ENG-SF22036-R1-Util-CDs.pdf Markup Summary

Subject: Callout
Page Index: 1
Date: 1/23/2023 5:14:51 PM
Author: CDurham
Color: ■
Layer:
Space:
Page Label: [1] 1 118323-TITLE-01 - Layout1

SANITARY SEWER PLAN

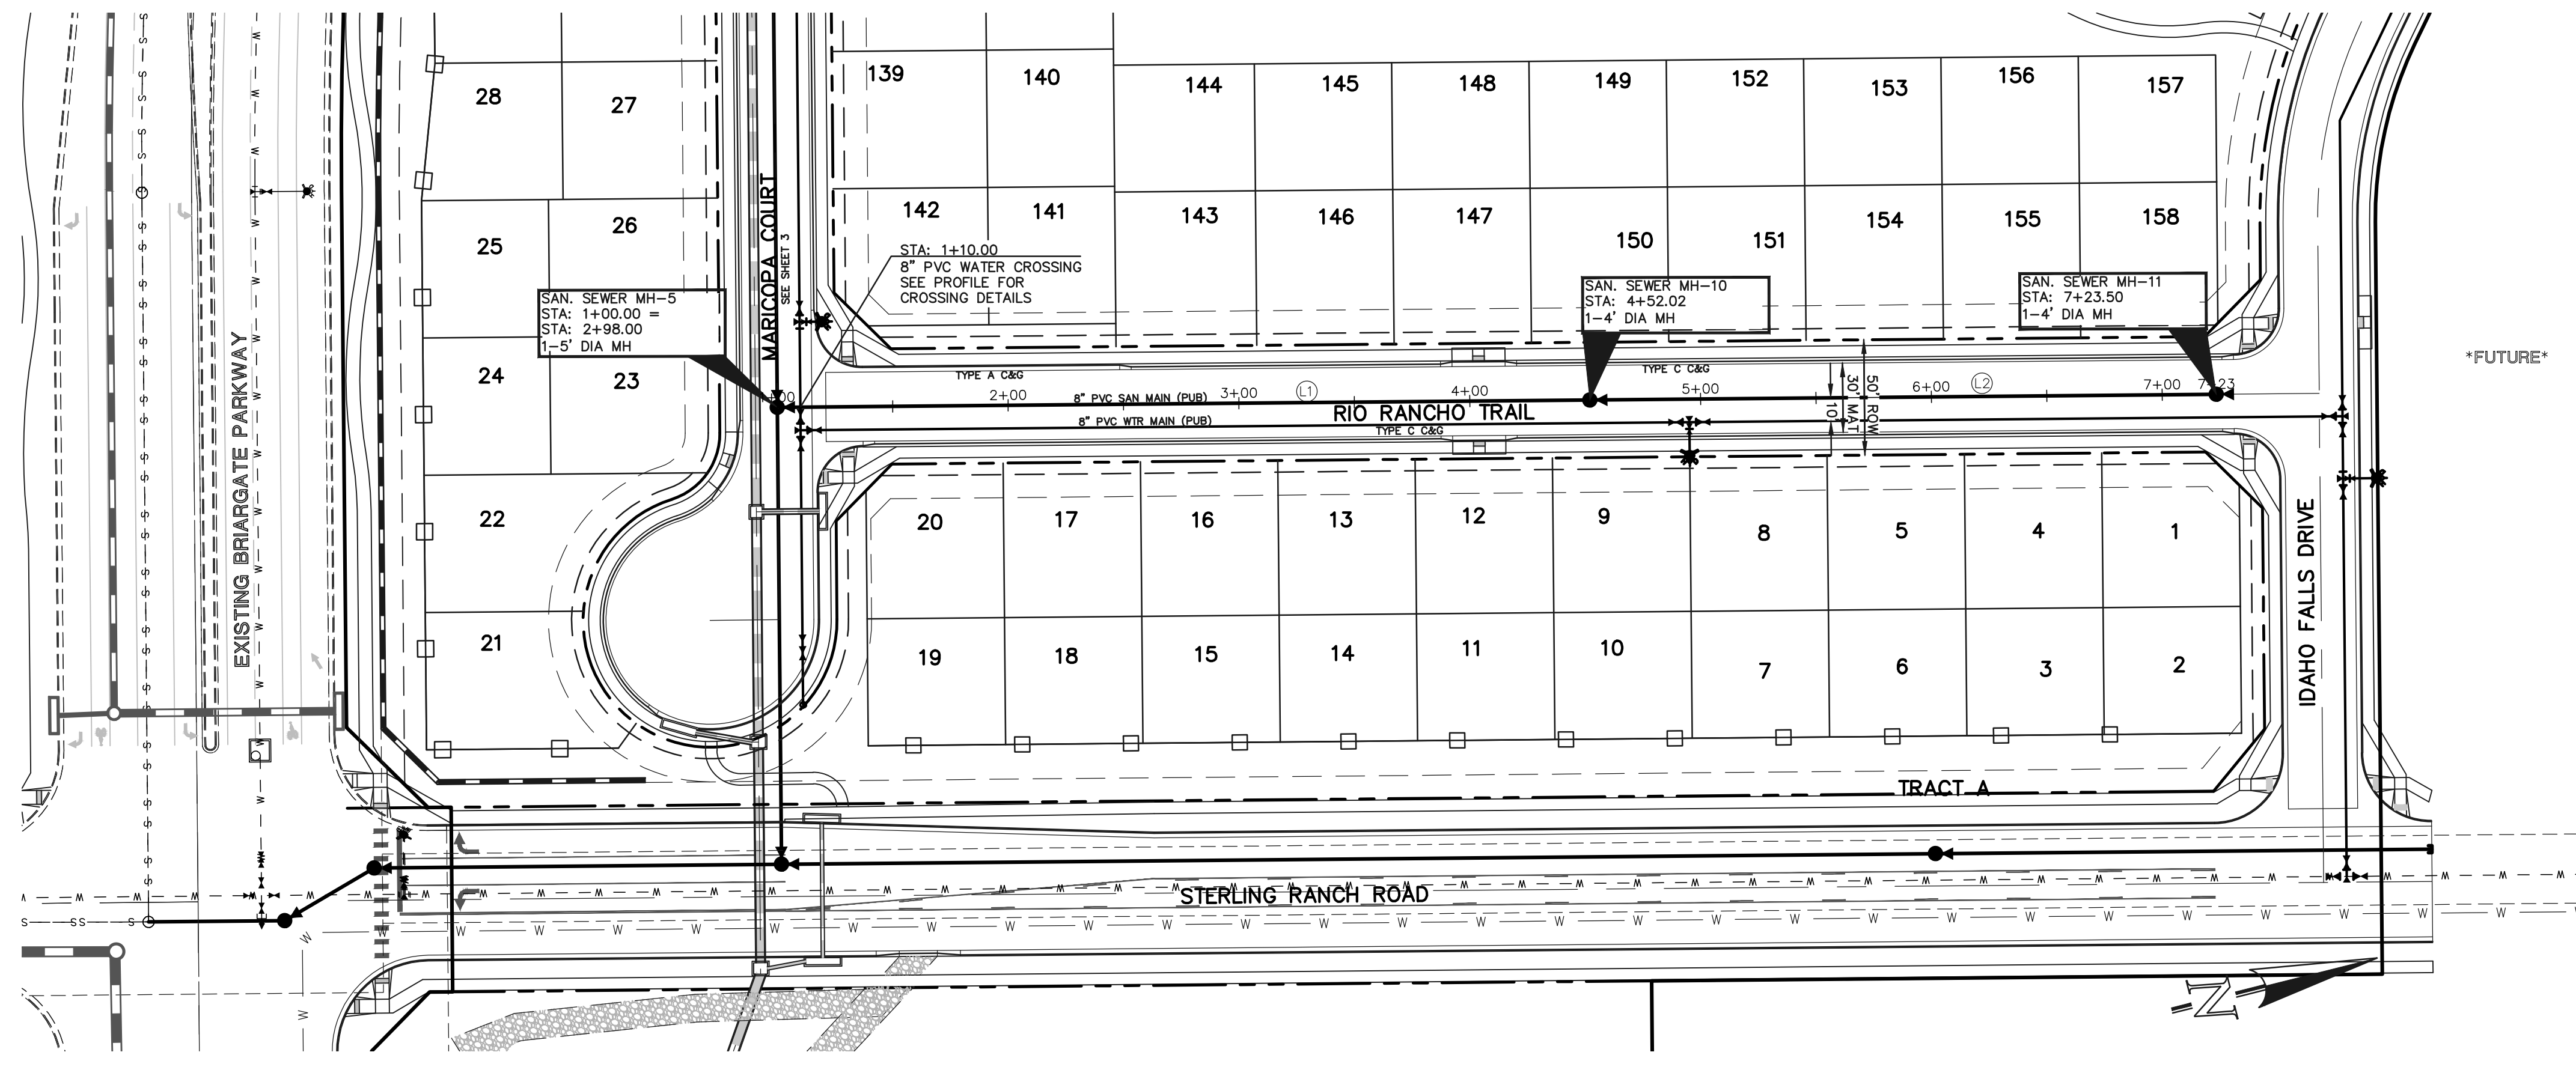
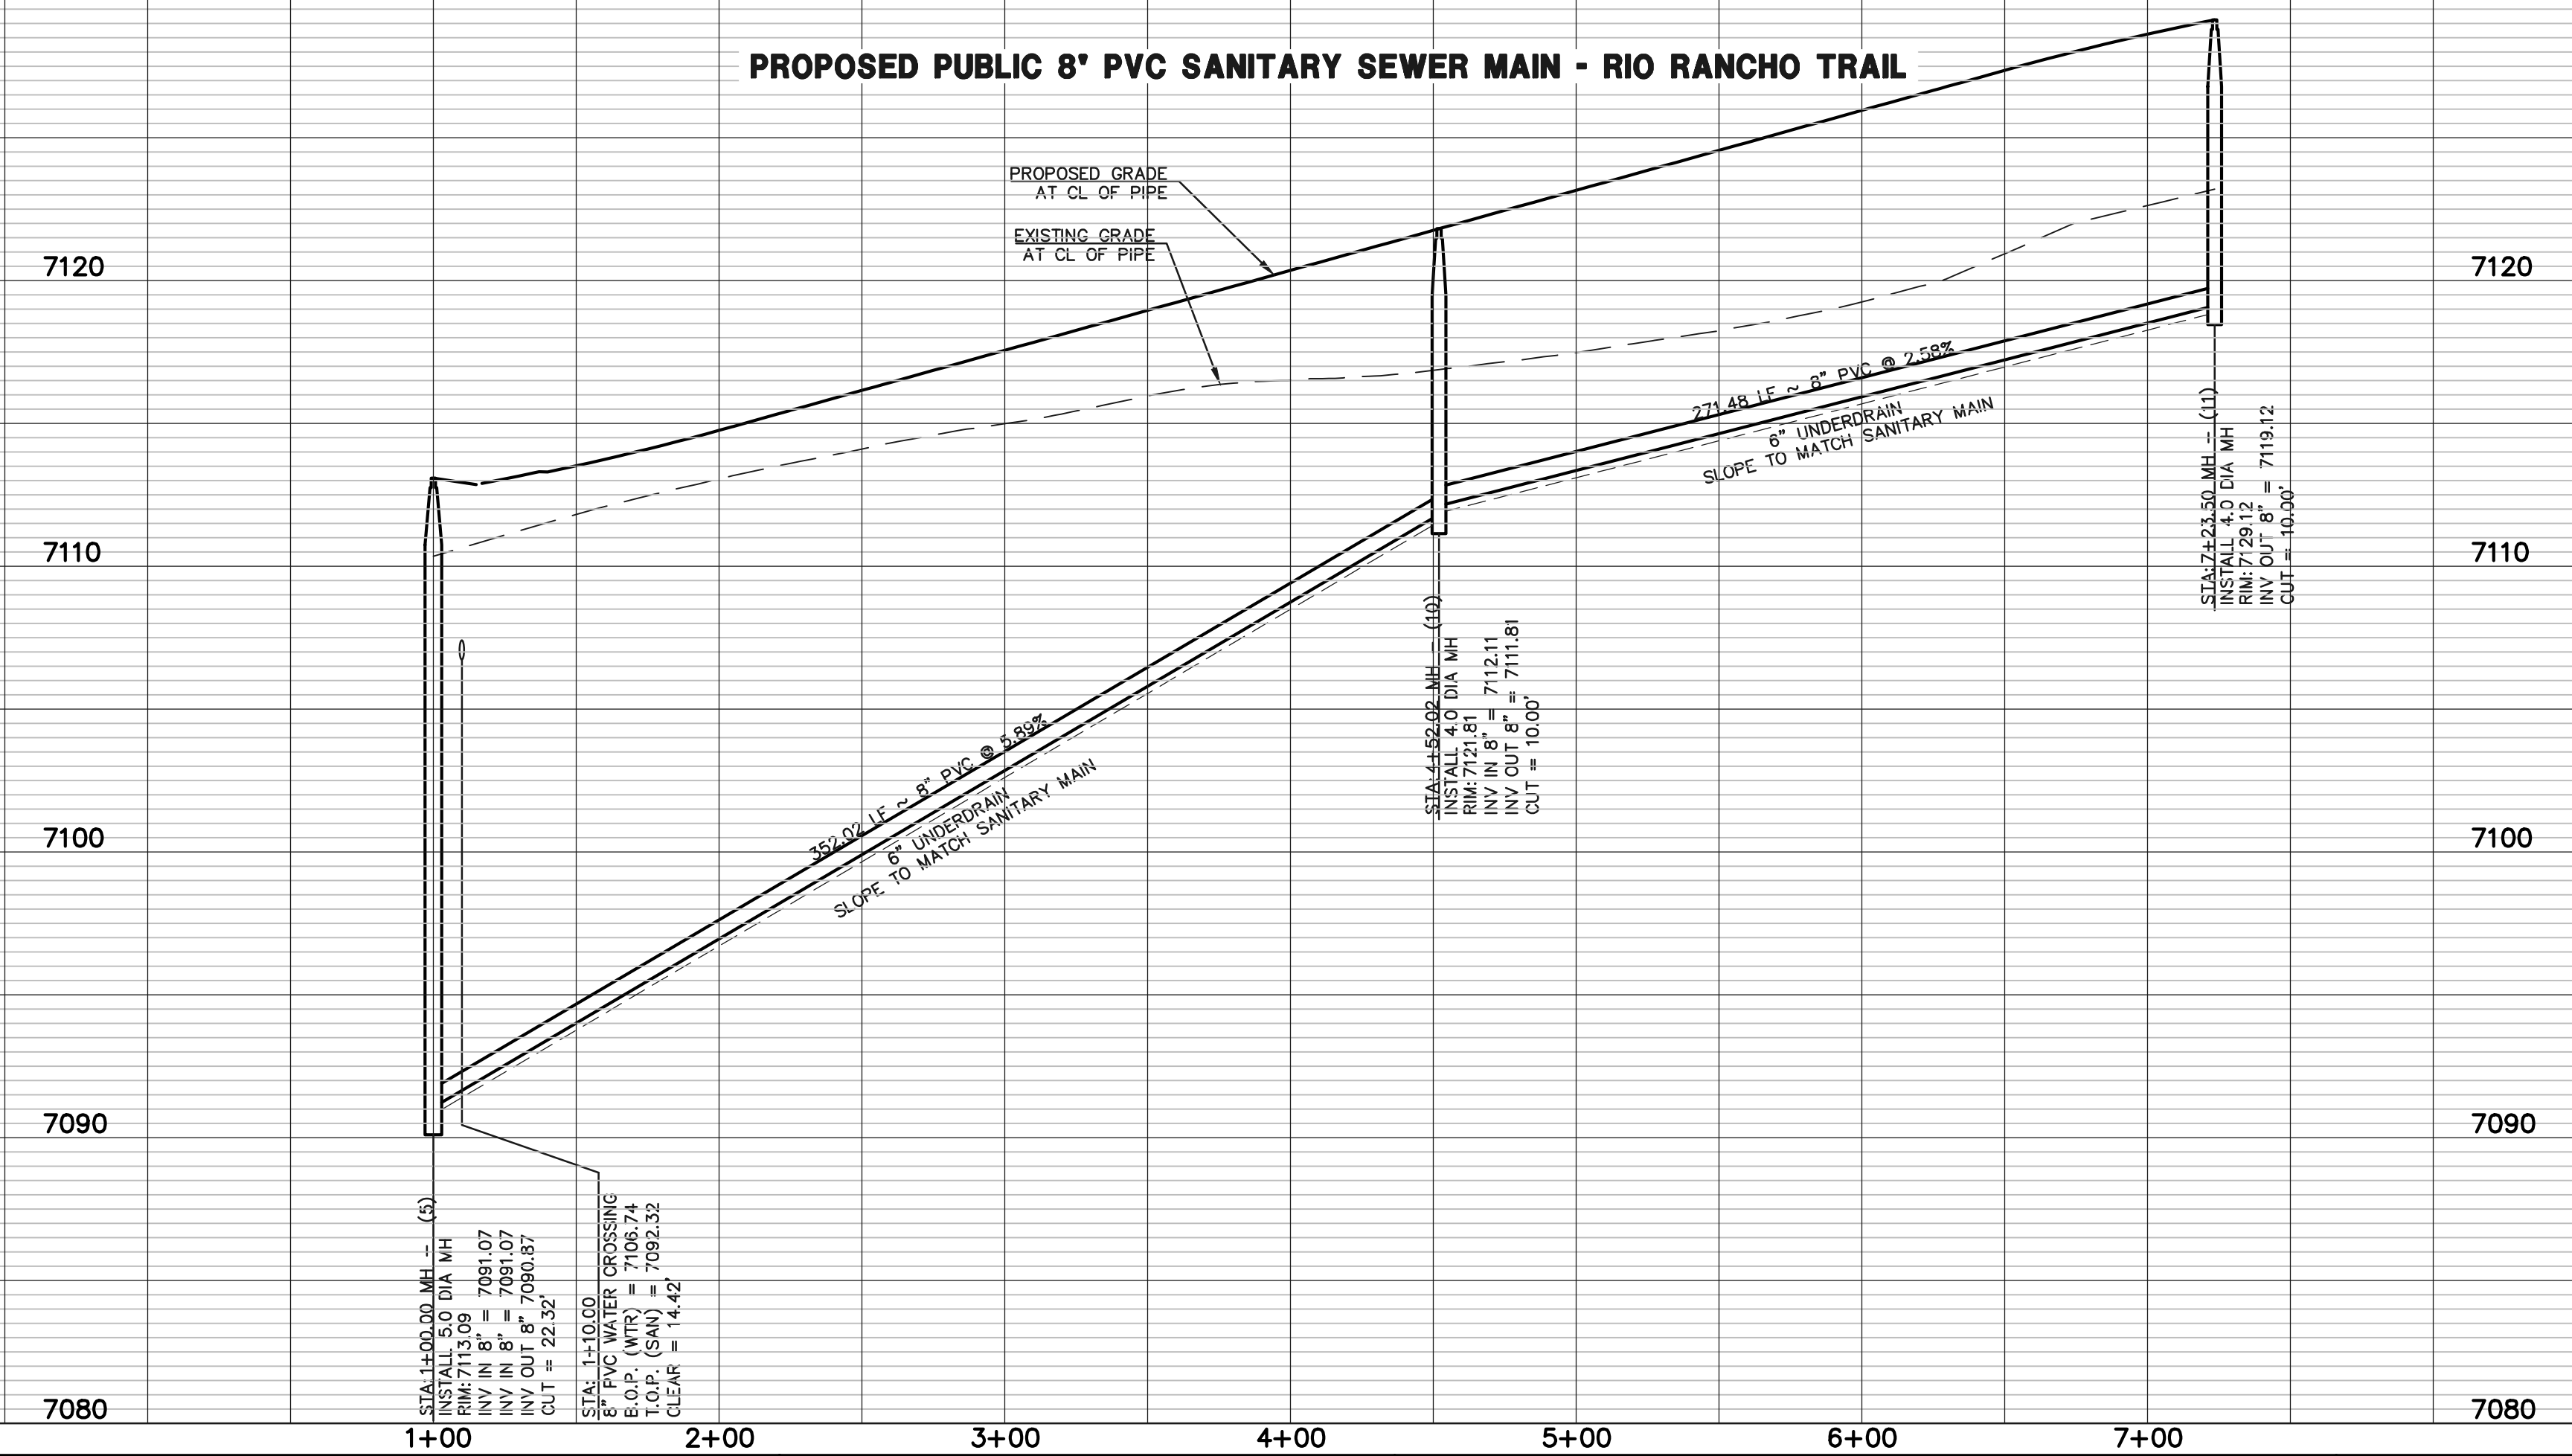
Label storm crossing

| DRAWN BY | JRH | (H) 1" = 50' | SHEET | 4 OF 11 |

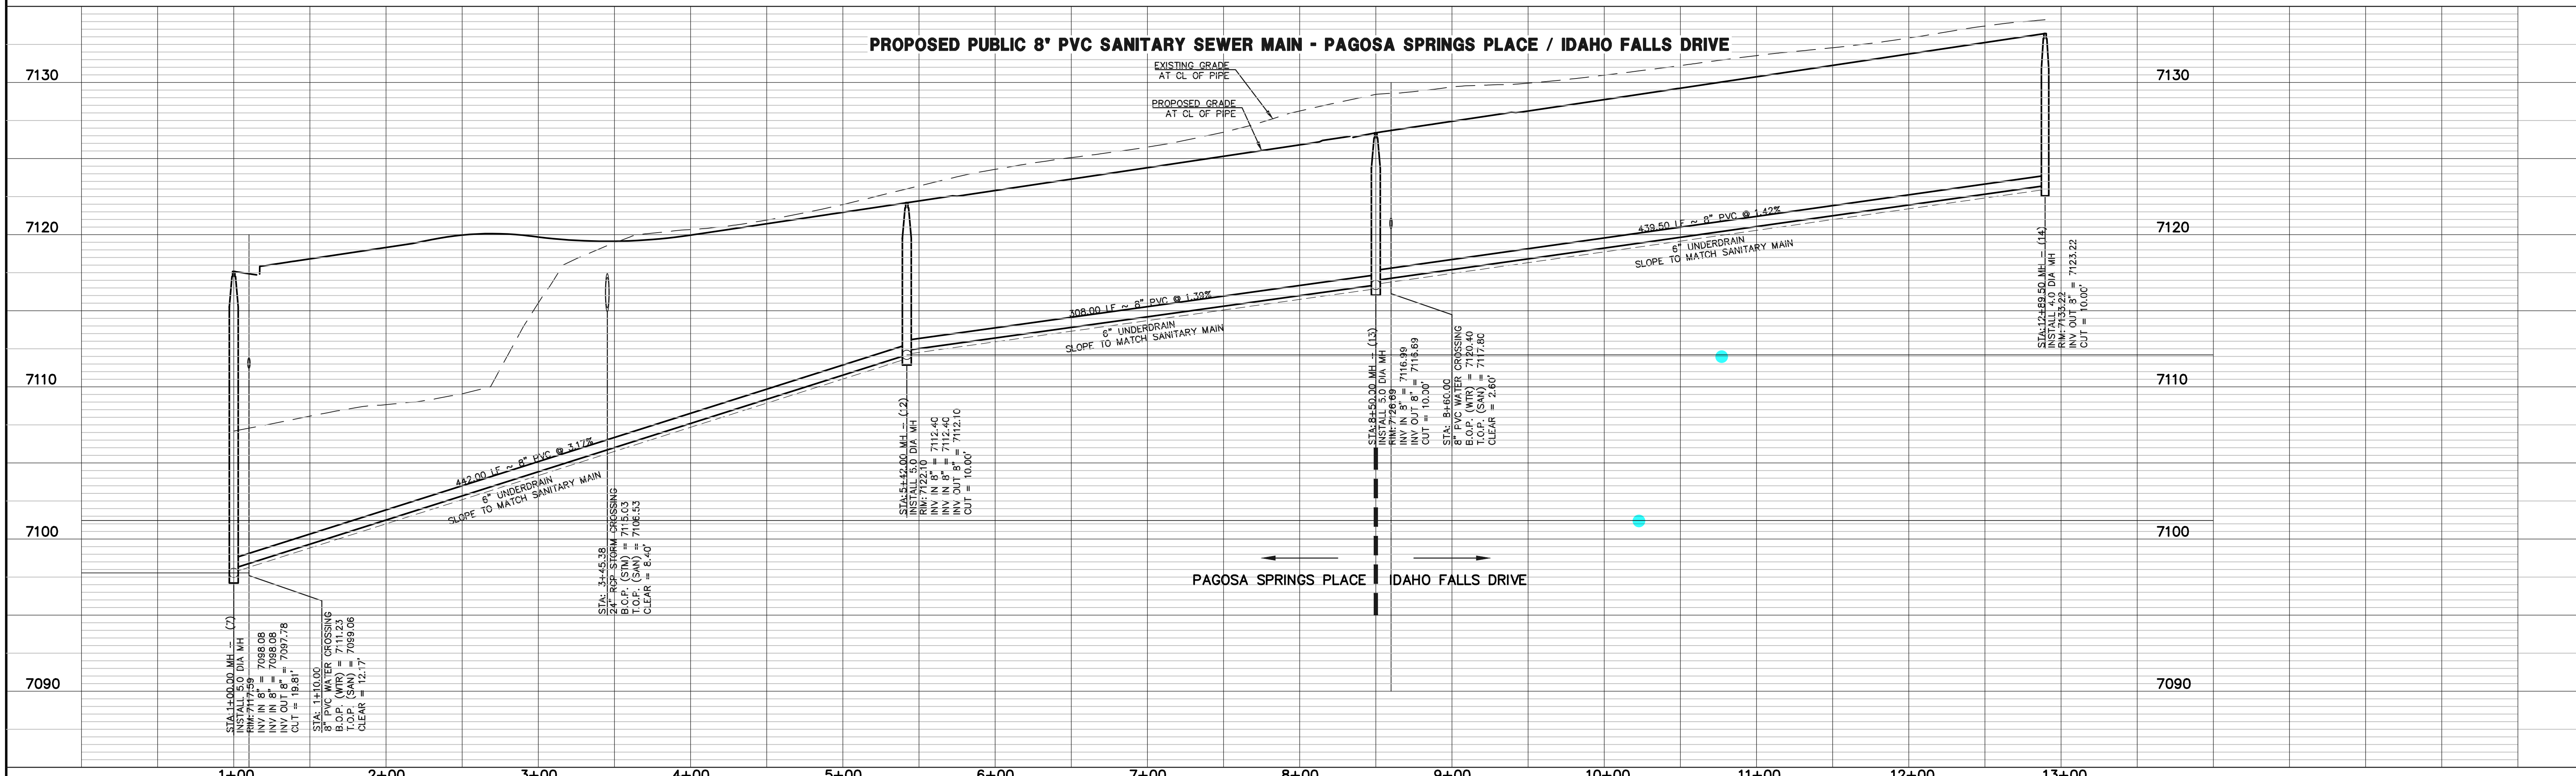
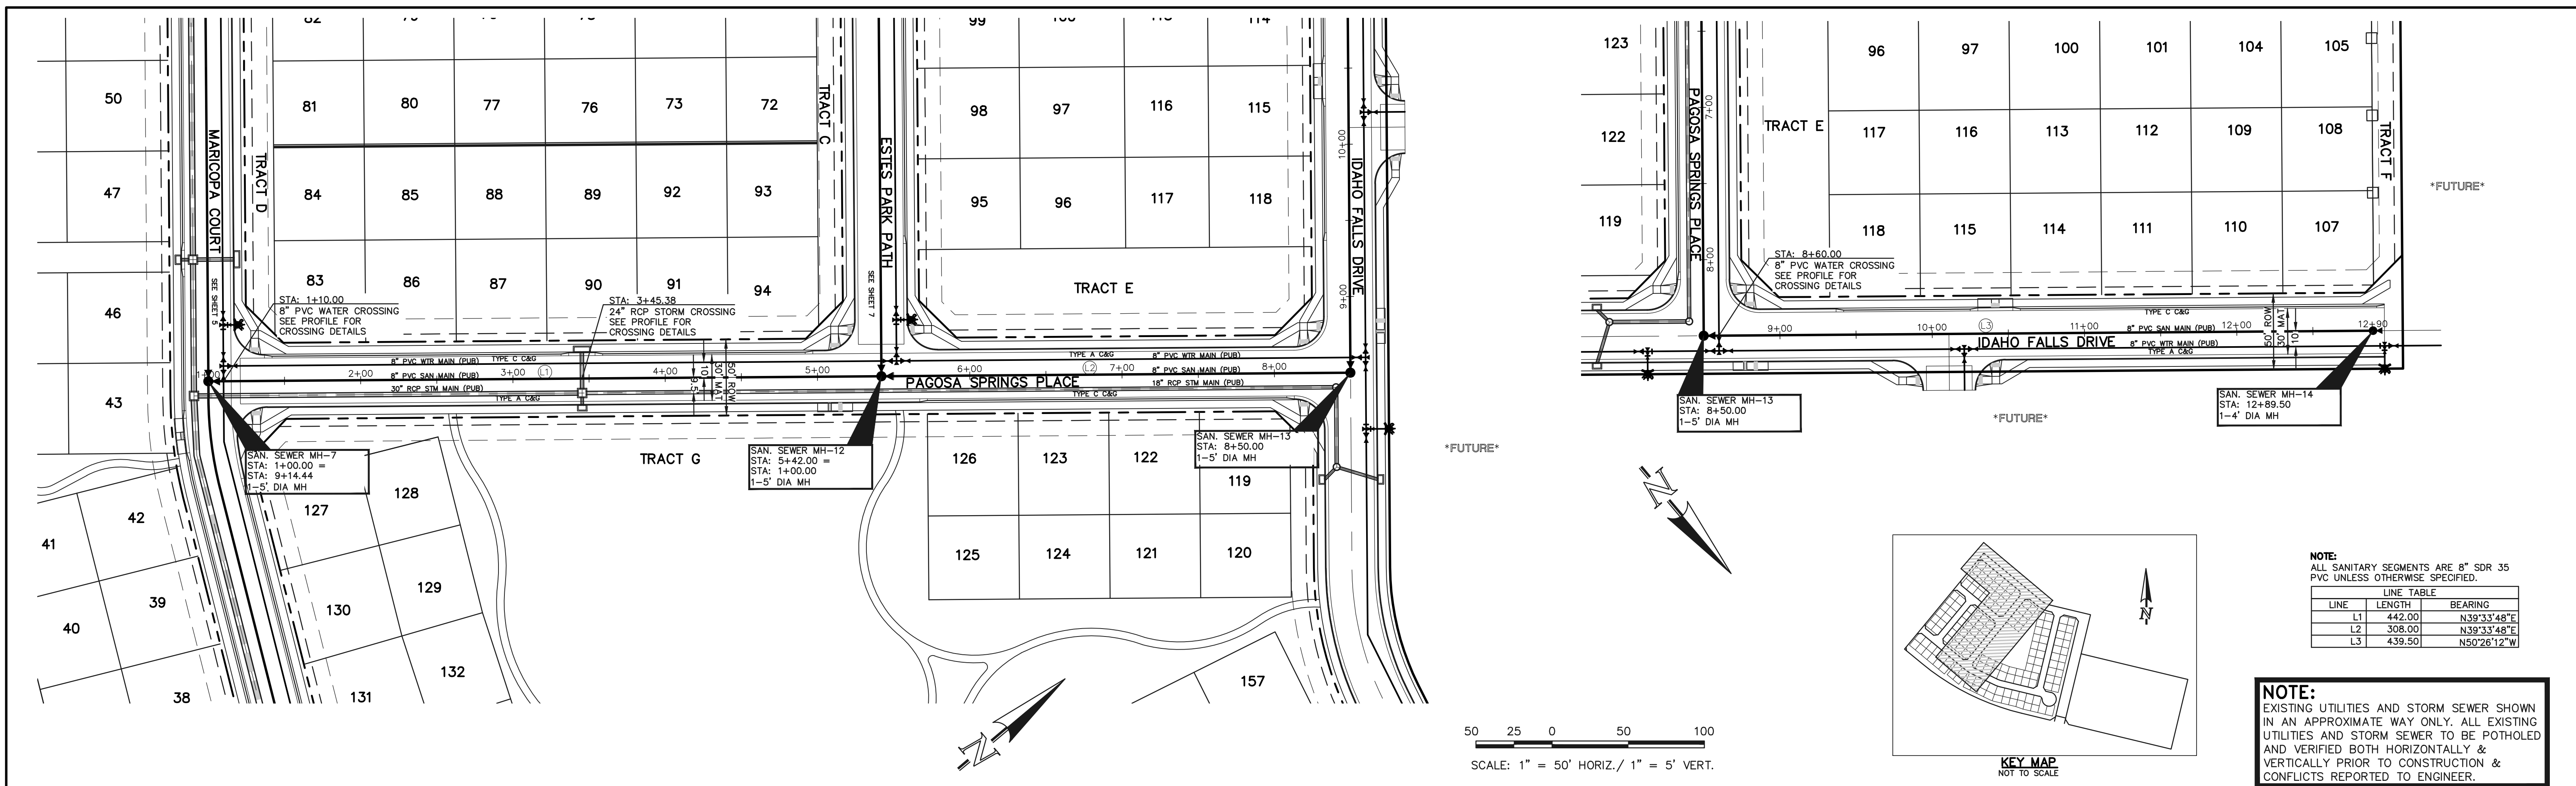
Delete extra lines
